# CITY OF ALBUQUERQUE

January 25, 2017

**Re: Advance Auto  
10026 Central Ave. SE  
60-Day Temporary Certificate of Occupancy- Transportation Development  
Architect's Stamp dated 05-19-16 (L20-D056A)  
Certification dated 01-19-17**

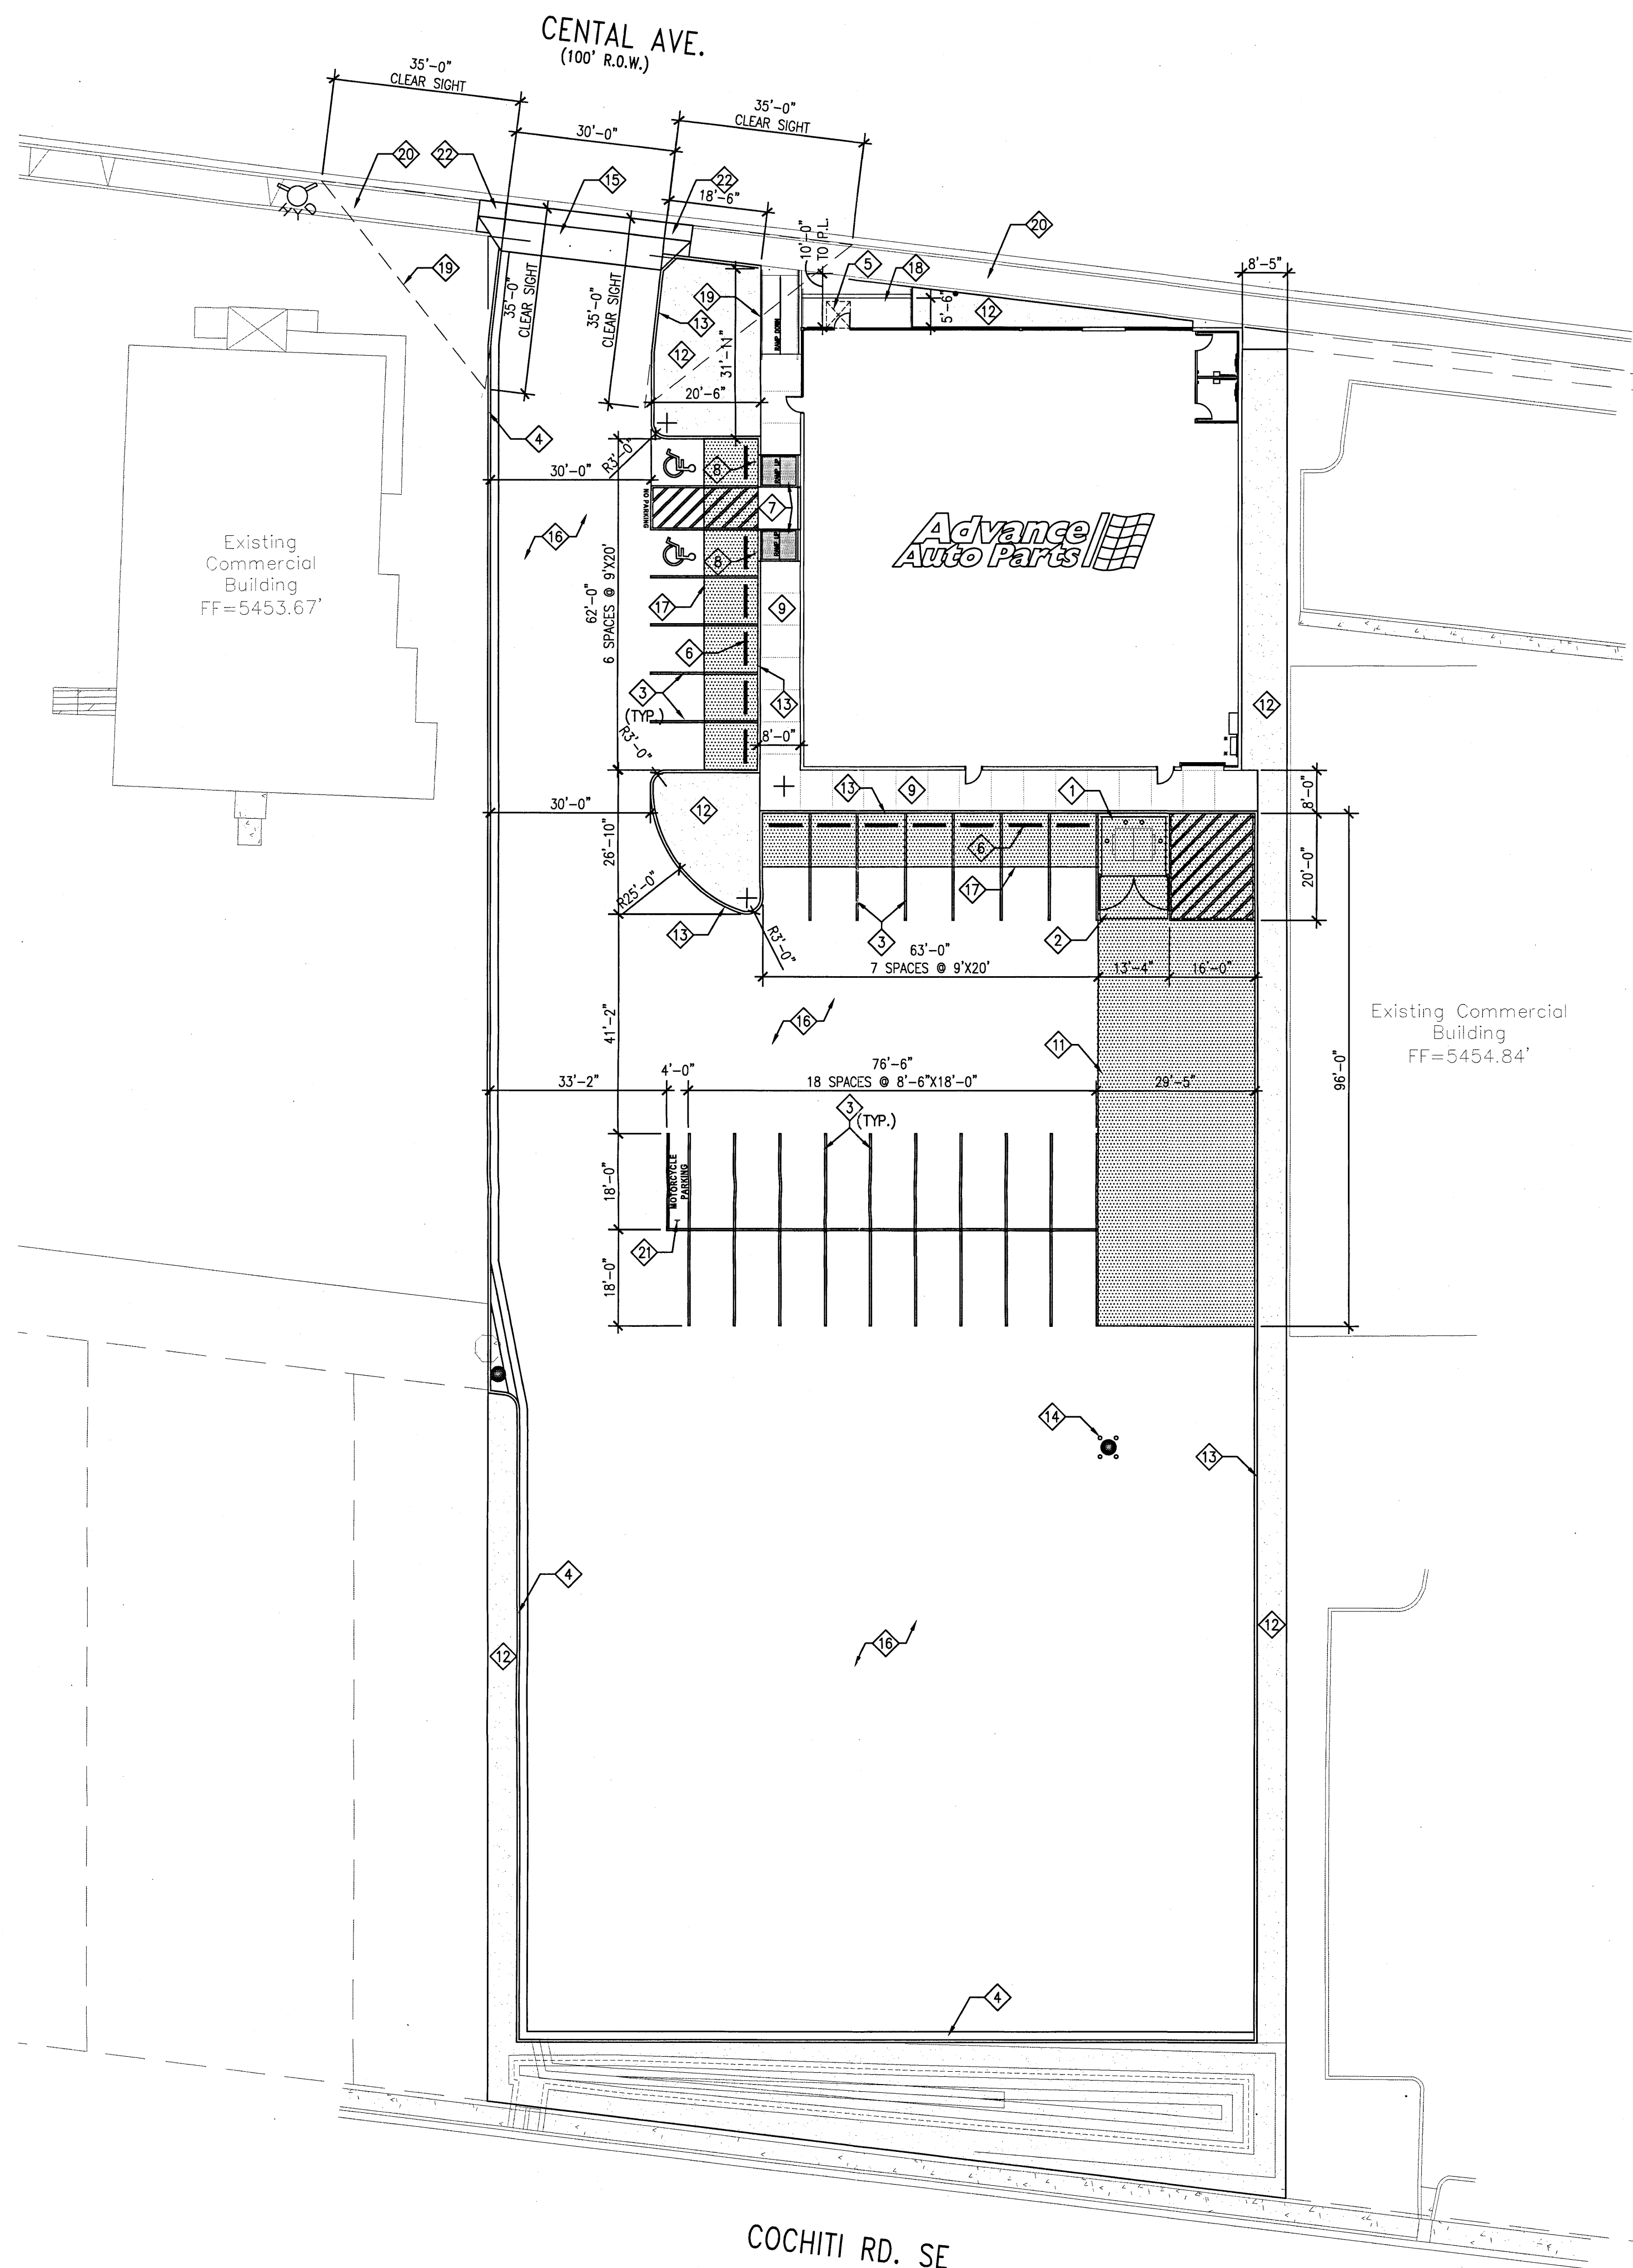
1. There are two accesses on the South side of the site, one on the West side and one on the East side. The accesses must have access agreements with the neighbor properties or they will need to be closed.
